Application for a non-material amendment following a grant of planning permission.

Proposed Extensions and Alterations
Ashtree Farm Randall Bank
Moulton Eaugate Spalding Lincs

H23-0145-11

Amended Elevations to the Garden Room.

Project	Ashtree Farm Randall Bank Moulton Eaughton Lincolnshire PE12 0RT		
Dwg.	Key Plans, Elevations and Sections		
Scale	1:100 @ A1	Date	May 11
Dwg No.	10-2024-WD-02	Rev.

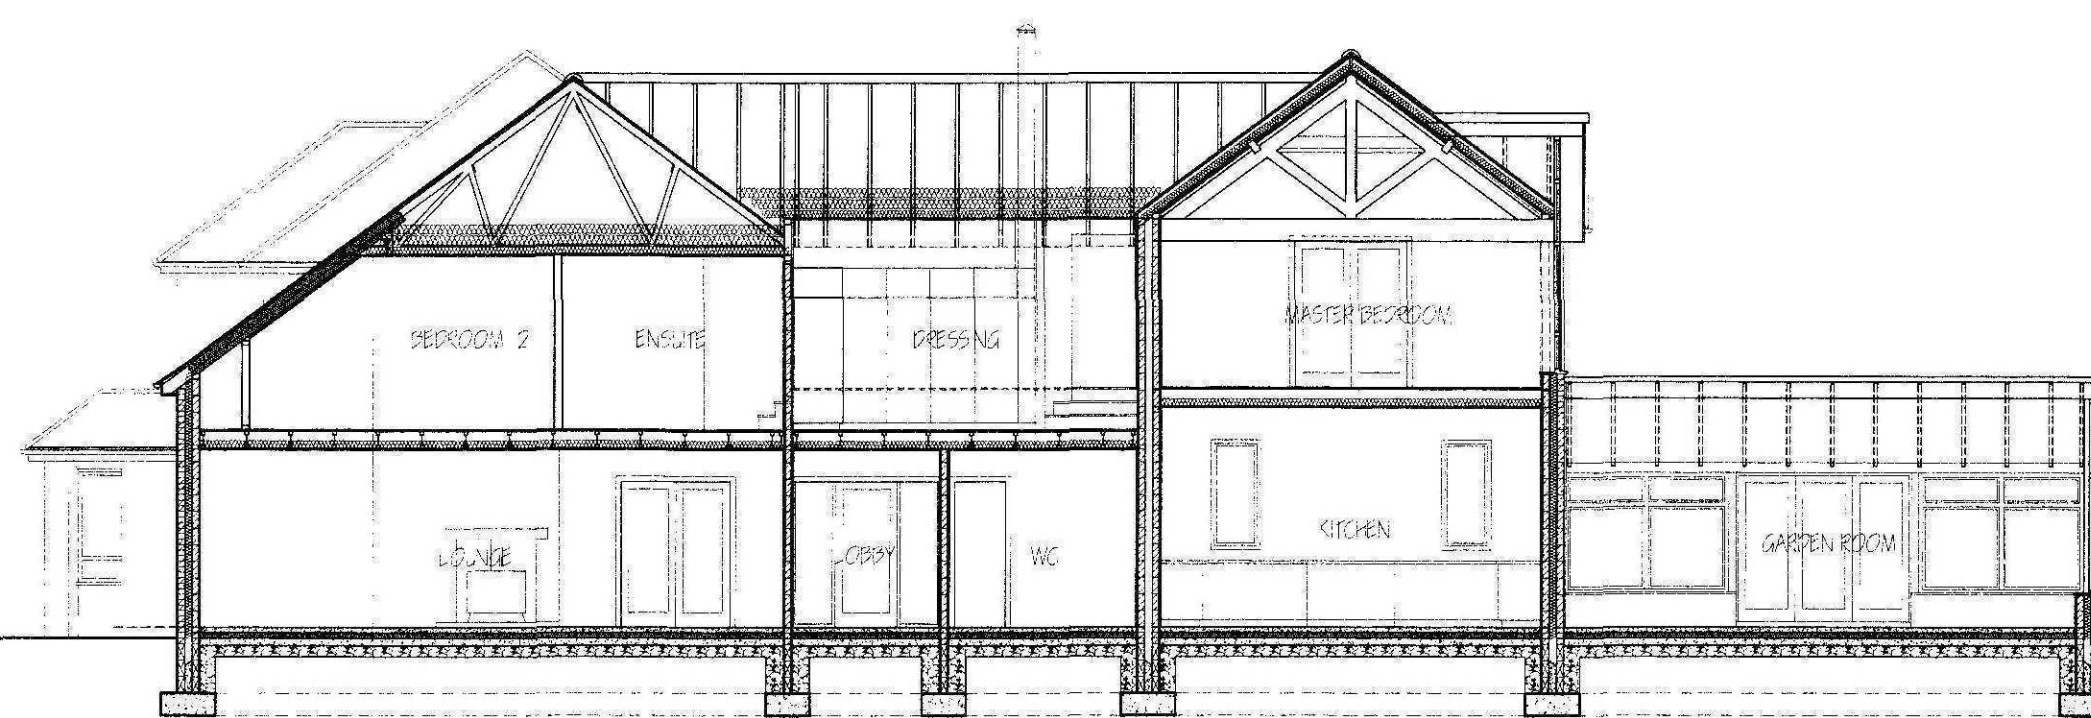
To avoid hipped roof butting up to the external wall of the new Kitchen/Breakfast Room.

10-2024-WD-02
